Application for Planning Permission for Works or Extension to a Dwelling

Development: Part single, part two storey rear extension, dormer extension and alterations to fenestration.
Location: Flints Hoe Lane Flansham PO22 8NP

Proposed West Elevation

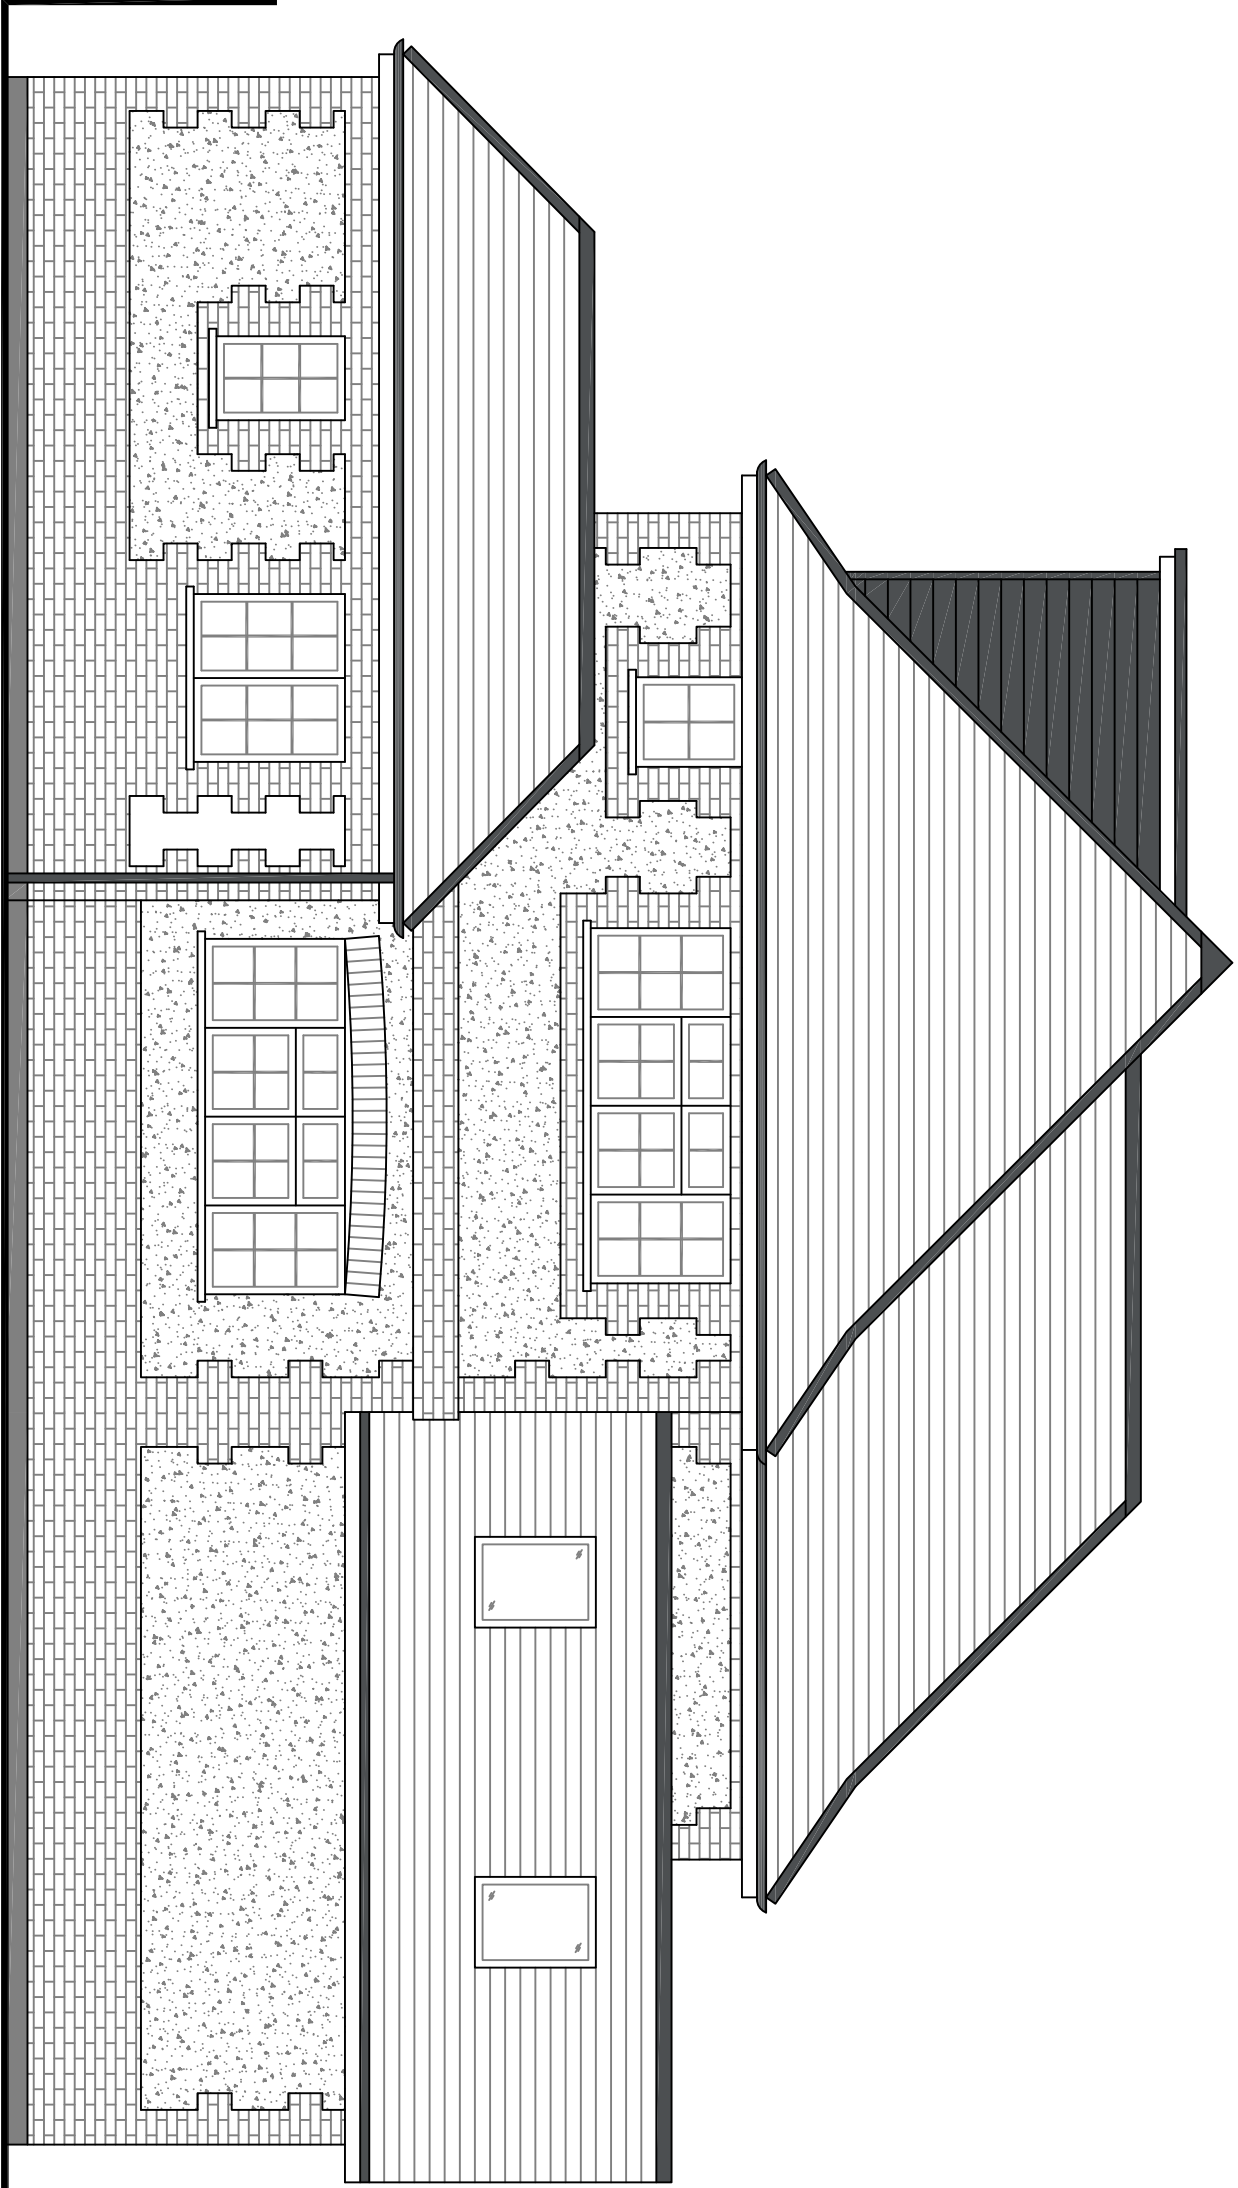
The w/c window on the first floor plans are missing from the west elevations, please review and amend.

Proposed South Elevation

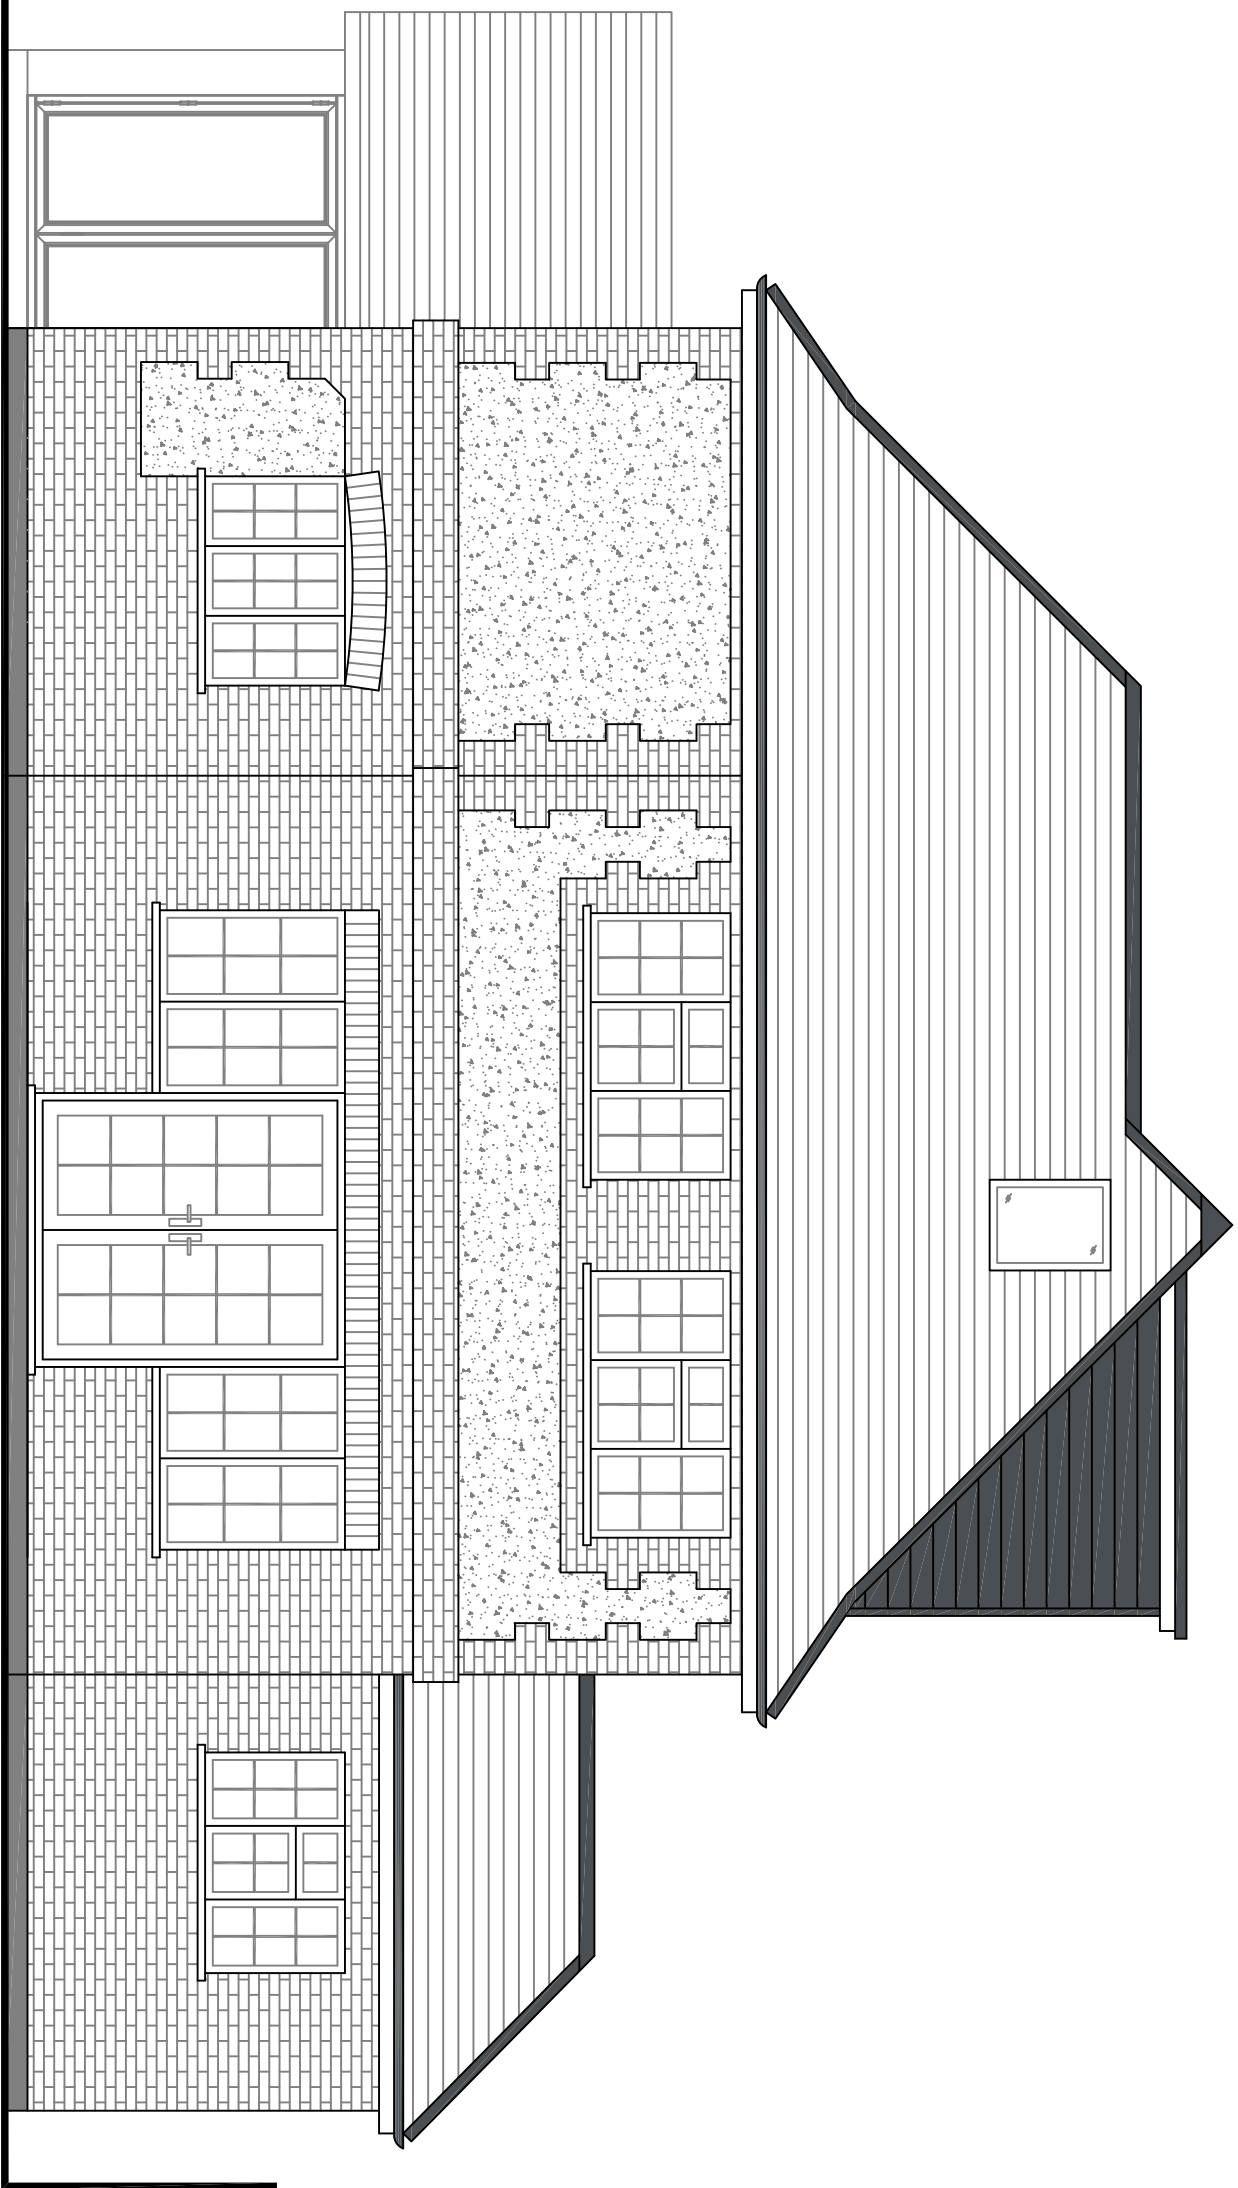
The proposed south elevation has a building line which is inconsistent with the proposed ground floor plan, please review and amend accordingly.

Proposed North Elevation

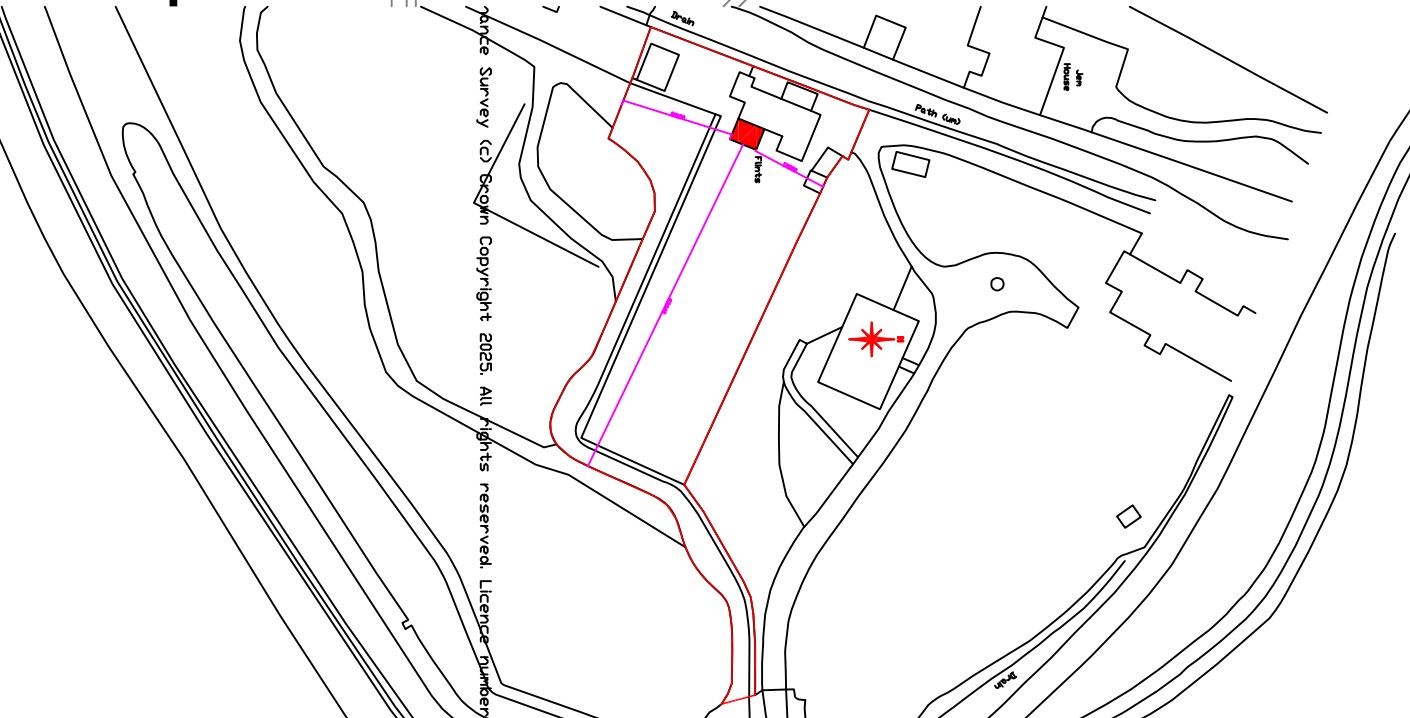
The north elevations are inconsistent with the ground floor plans, please review and amend.

Proposed Extensions and Alterations

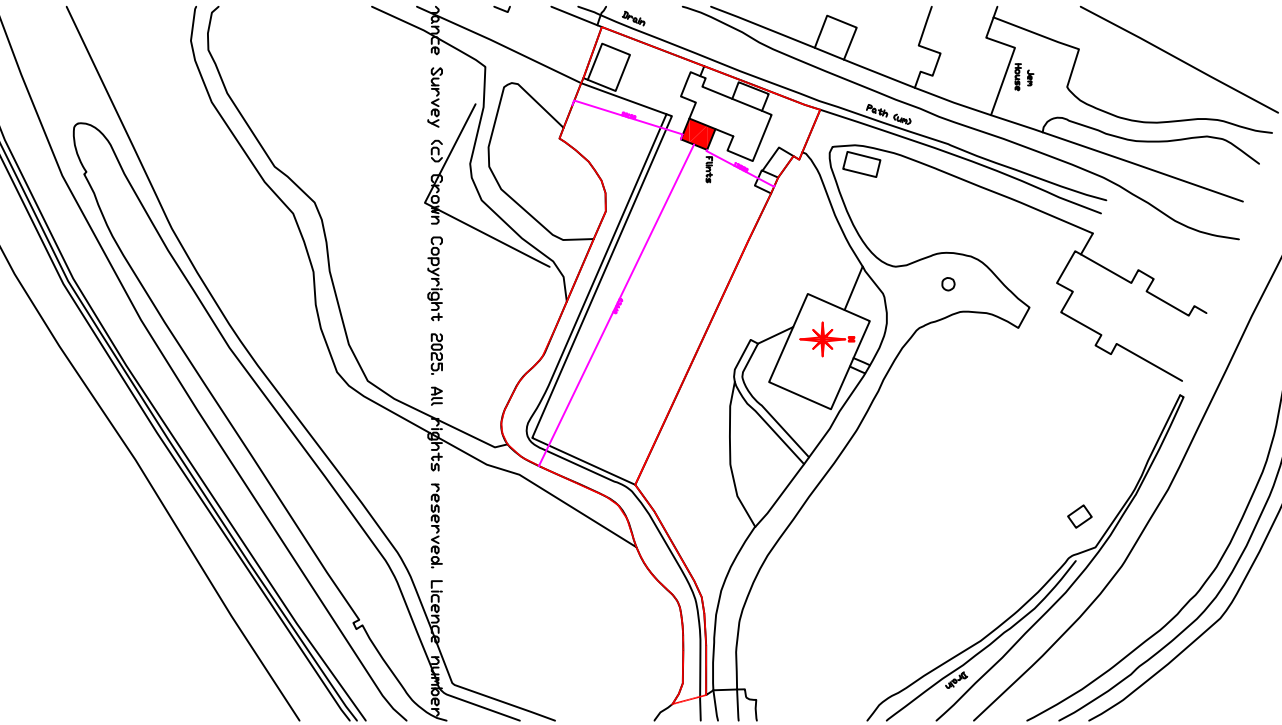
You are required to have dimensions from the proposed extension(s) to all site boundaries. Please amend.
